The Director, Resource Assessments
NSW Department of Planning, Industry & Environment
GPO Box 39
SYDNEY NSW 2001

5 June 2020

SOUTH 32 RESPONSE – DENDROBIUM MINE EXTENSION PROJECT

Figure 2.2
Proposed Dendrobium Mine Layout

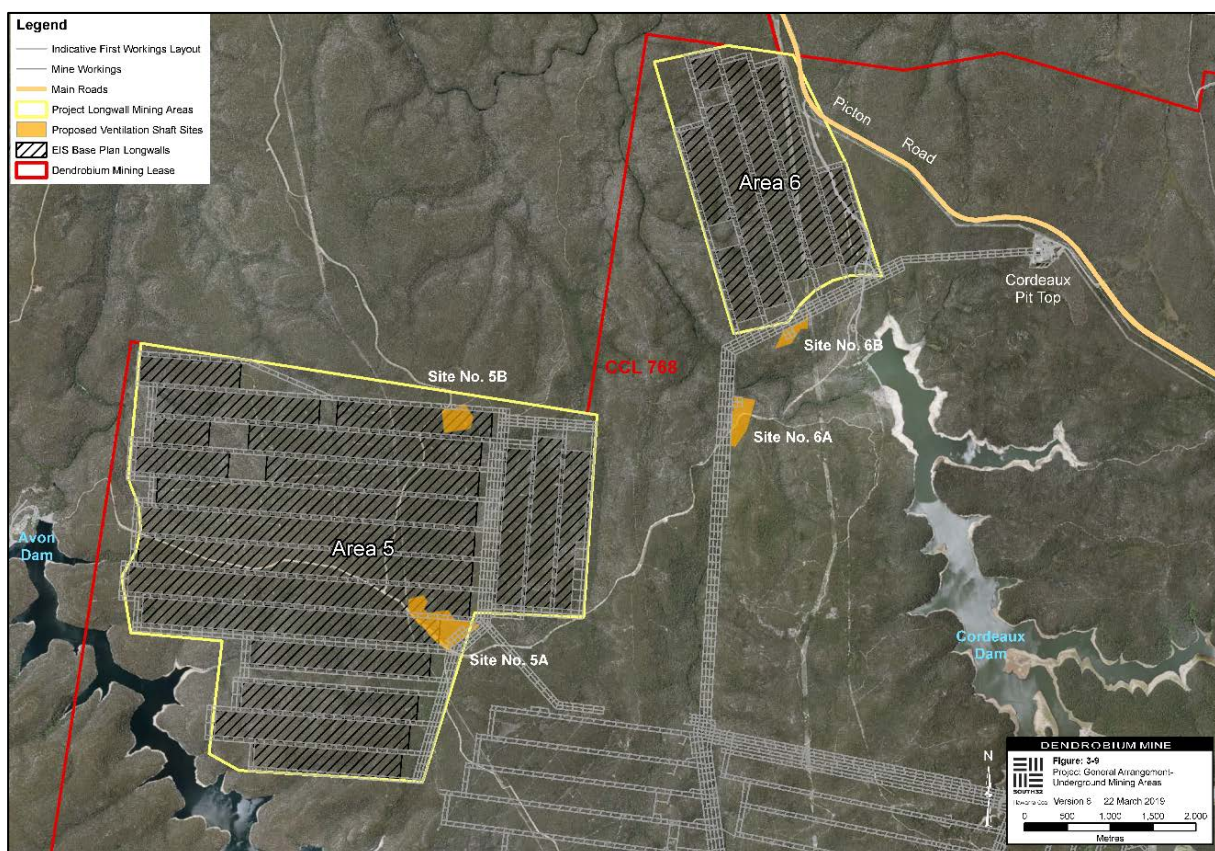
Council recognises the importance of local coal mining to the local, regional and domestic economy. However, Council remains concerned over the extent of subsidence related impacts upon watercourses and coastal upland swamps due to the current proposed mine layout, particularly the proposed 305 metre wide longwalls. Council is also specifically concerned about the cumulative loss of water to reservoirs, watercourses and upland swamps in the drinking water catchment areas. Therefore, Council requests that the Department consider the South 32 modelling of the different possible longwall widths and the associated subsidence and water loss impacts upon the catchment, in order to reach the right balance between the proposed mining activity and protecting water resources.

South 32 acknowledges Council's previously raised concerns that all 58 Aboriginal heritage sites have the potential to be impacted by subsidence due to their proximity to the project area (ie they are located directly above or proximal to the longwalls). In Council's view, a redesign of the project mine layout should be considered to reduce the subsidence impacts upon the Aboriginal heritage sites.

The actual mine layout redesign should be determined by the Department, following a review of likely subsidence impacts associated with the South 32 modelling of different longwall widths.
